From: Tim Townsend [<mailto:tim.townsend@westsussex.gov.uk>]
Sent: 07 November 2017 14:32
To: Planning.Responses
Cc: Michael Eastham; Gary Markwell
Subject: LU/121/17/RES - Approval of reserved matters for parcels C1 and part parcels B2, B4 and C2 - Land at former Toddington Nurseries, Littlehampton - WSCC highways comments dated 7th November 2017

**WEST SUSSEX COUNTY COUNCIL
STRATEGIC PLANNING CONSULTATION**

SUBJECT: LU/121/17/RES - Approval of reserved matters following outline consent LU/47/11/ for construction of 126 No. dwellings together with internal road network, car parking & landscaping.

LOCATION: Land North of, Toddington Lane, C1 & part Parcels B2, B4 & C2, Littlehampton, West Sussex, BN17 7PP.

GENERAL ARRANGMENT DRAWING (1 OF 2)

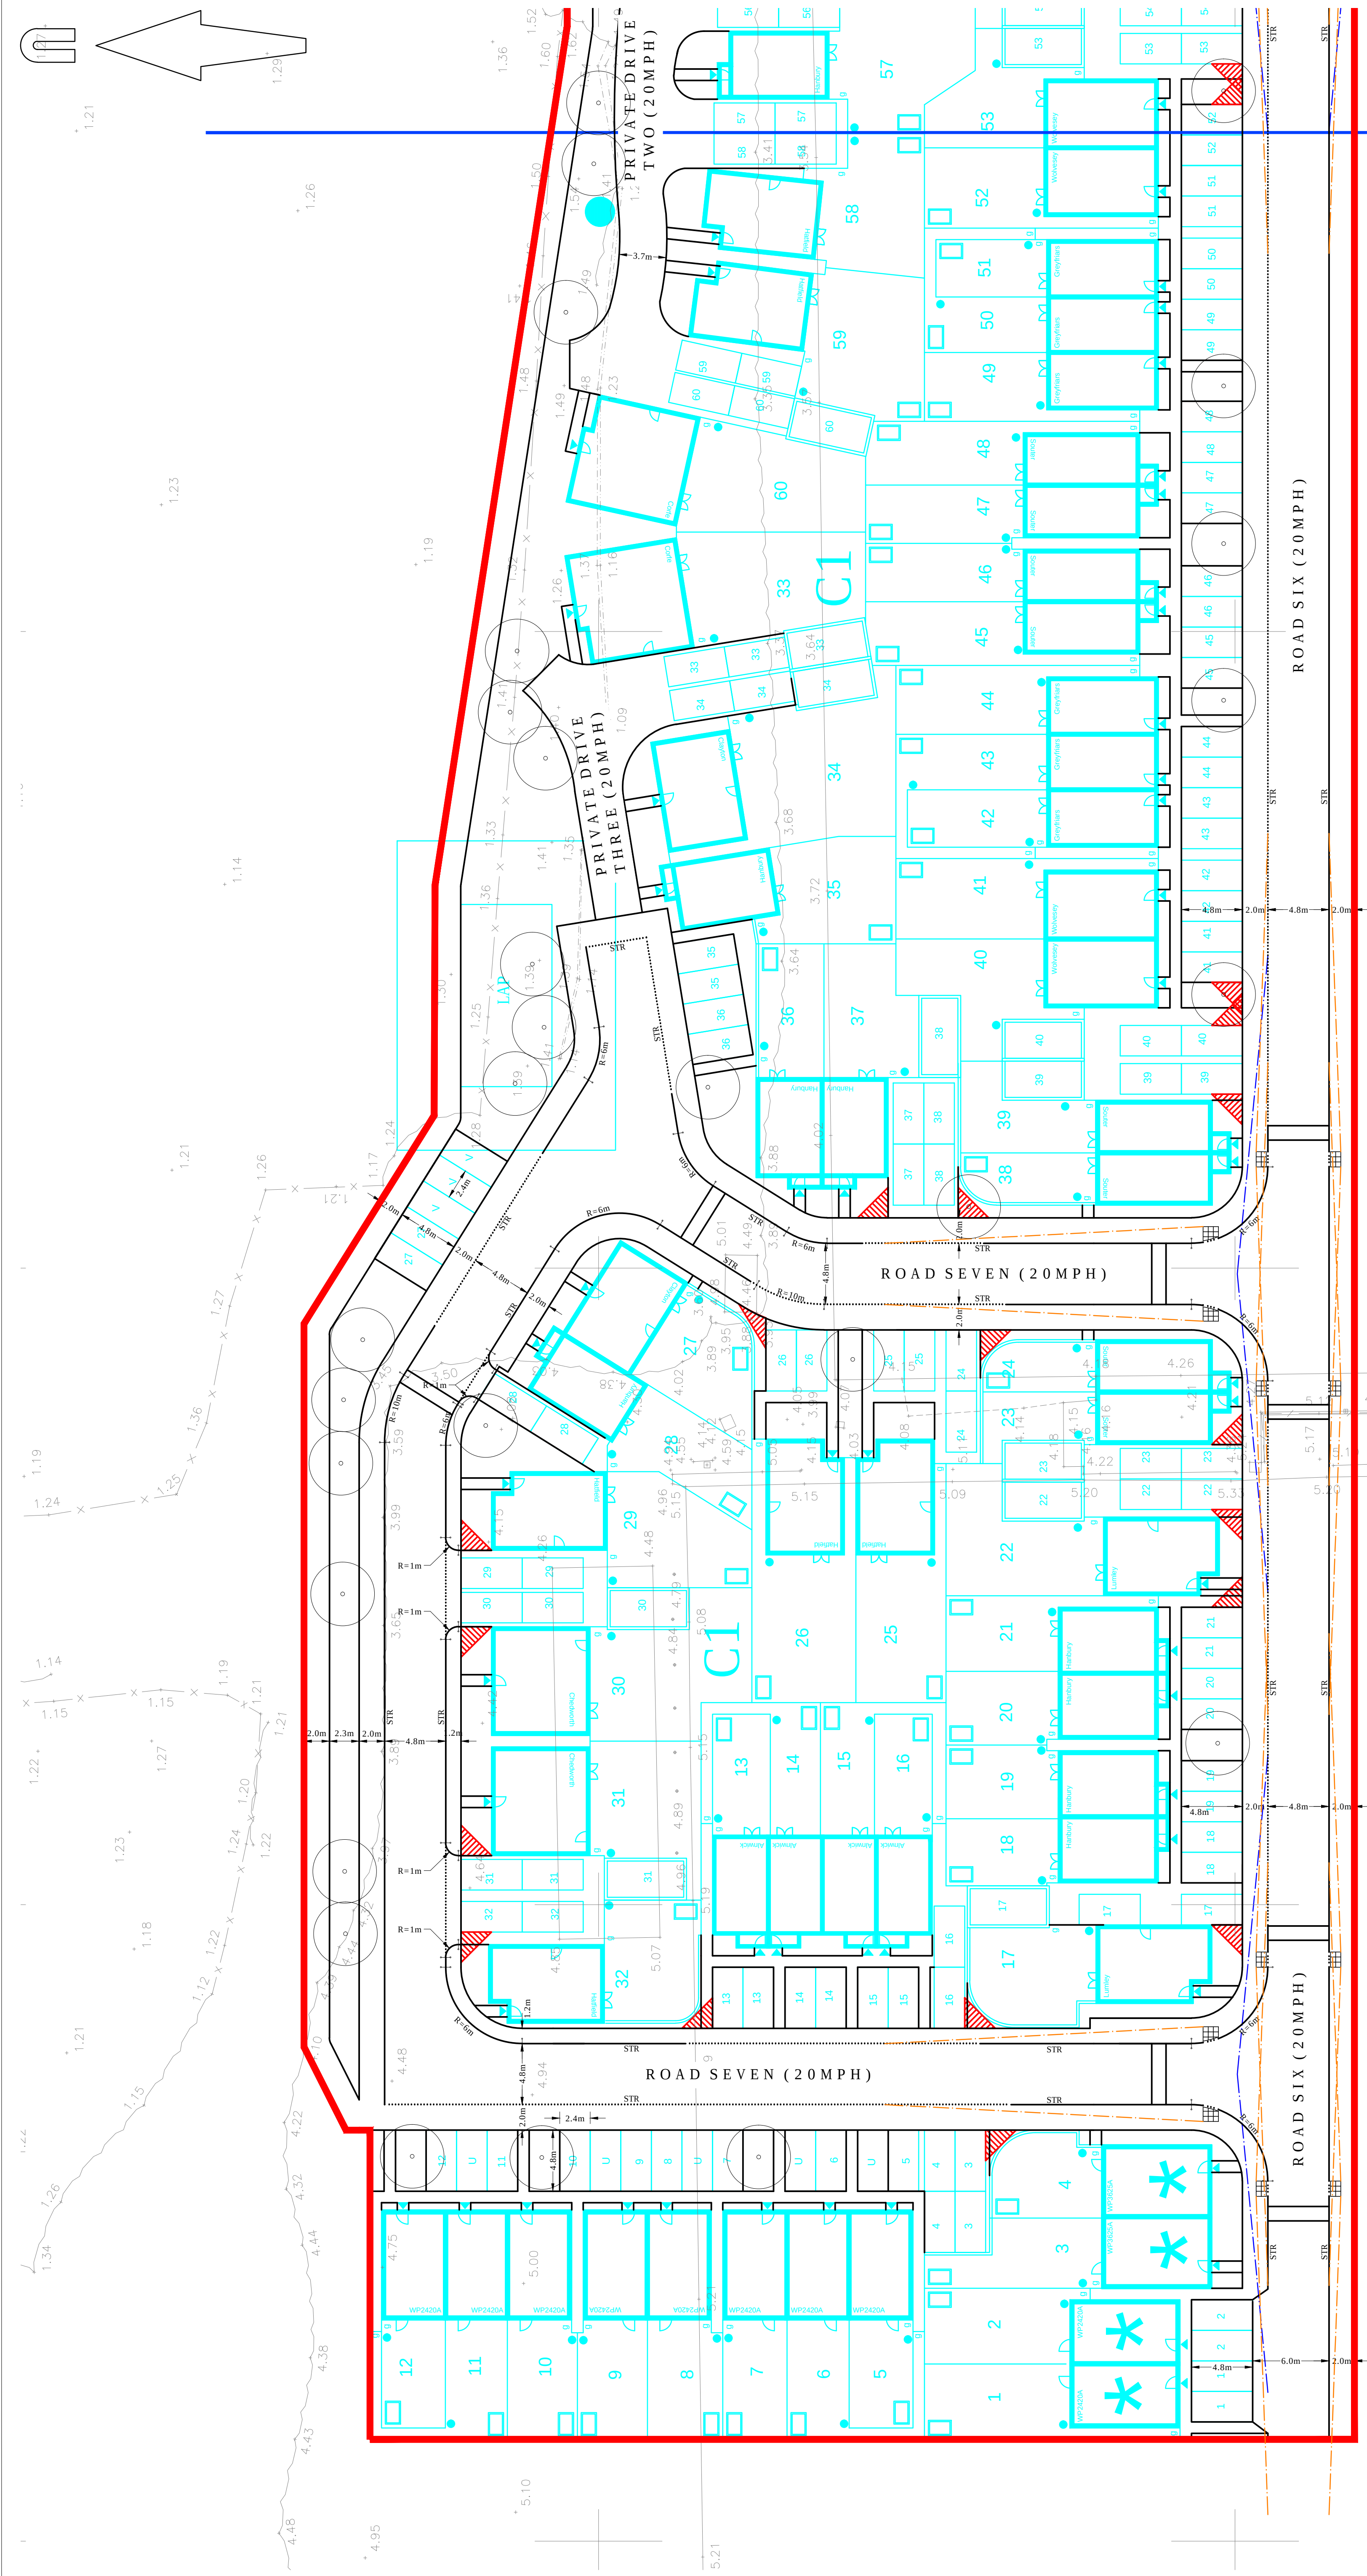
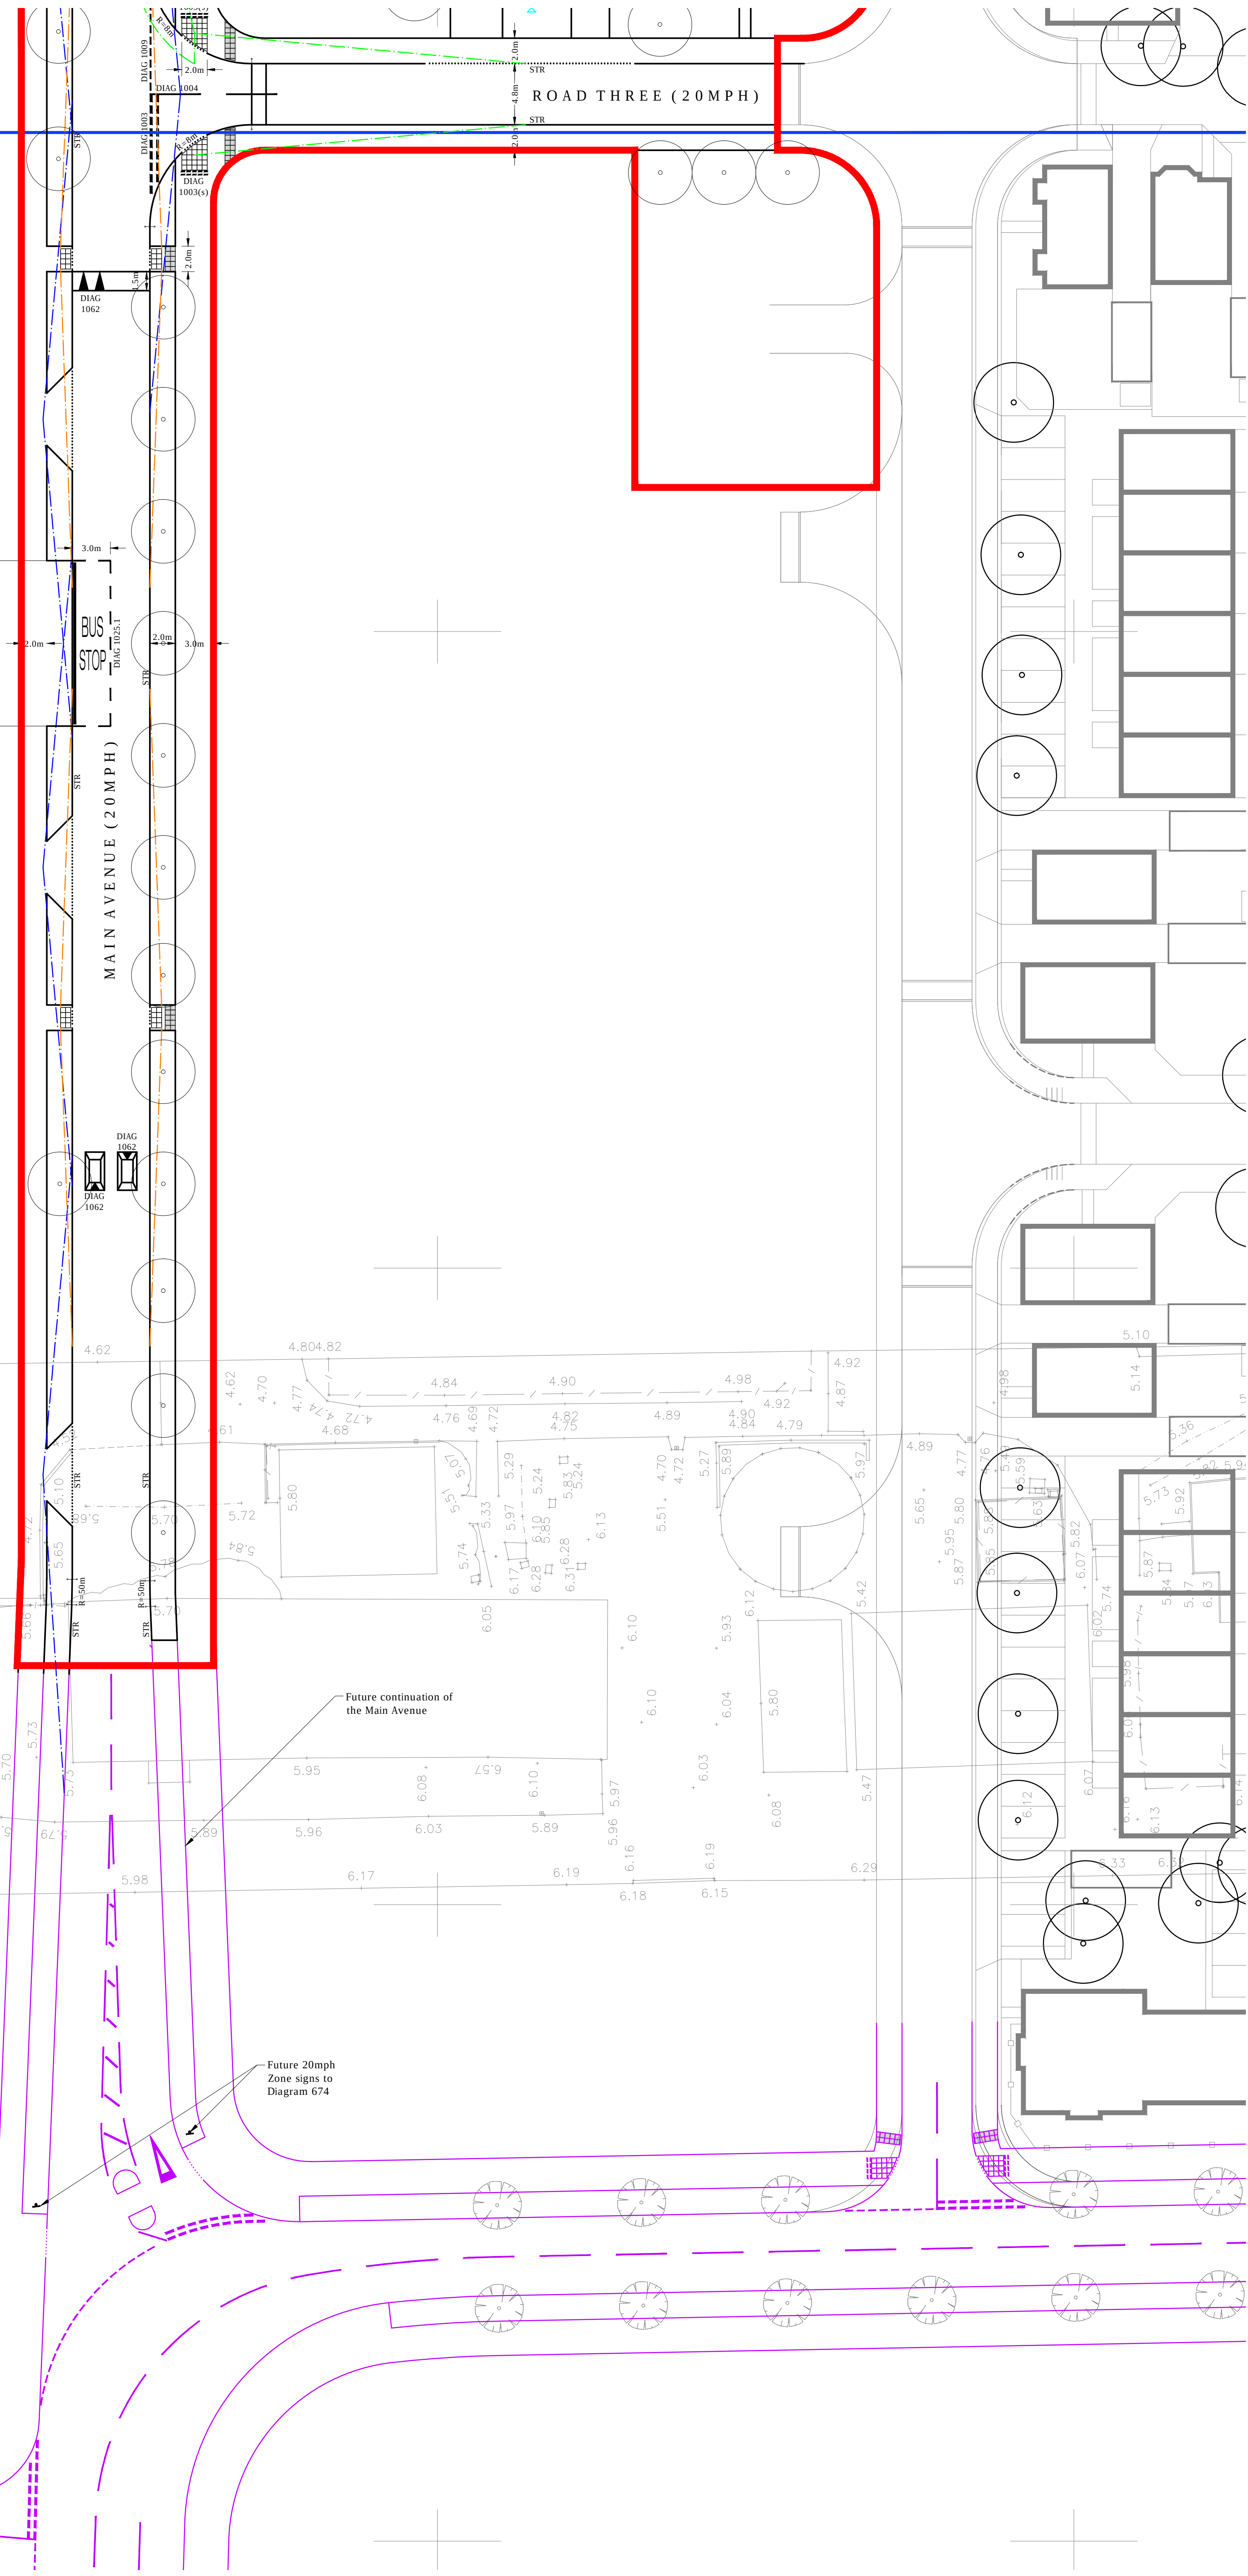
Surface treatments (roads, footways, landscaping etc.) – These are shown on Mayer Brown drawings A/PHLITTLE-INT.1/11-1 and A/PHLITTLE-INT.1/11-2 (although landscaping proposals are shown in more detail on White Young Green (WYG) drawing A088461 LA100.dwg). Road surface finishes are shown to be either traditional bituminous carriageways or block paving (private drives and raised table tops at some of the junctions – other than the tabletop adjacent to plots 80 and 95-100 which is in bituminous material). The applicant has explained that this latter one is like this for reasons of durability seeing as it is on the main spine road. This is accepted by the Highway Authority. It is recommended that further tactile paving be provided at appropriate crossing points as required and/or recommended at the S38/278 stage and/or as part of any Stage 2 RSA recommendations. Also, careful attention should be paid to the two proposed crossing

point locations so that any trees or other landscaping does not obscure visibility for pedestrians nor that of drivers approaching said area (as currently might be the case looking at the submitted drawings). Further crossings might need to be considered along this length on desire lines at the S38/278 stage.

Finally with regard to pedestrian and cycle movement – specifically where trees are proposed next or close to pedestrian crossing points - that adequate visibility is provided for users. Although this is now generally shown based on Manual for Streets (MfS), please also see comments elsewhere in this report about final design and location of said crossing points in relation to landscaping/trees etc.
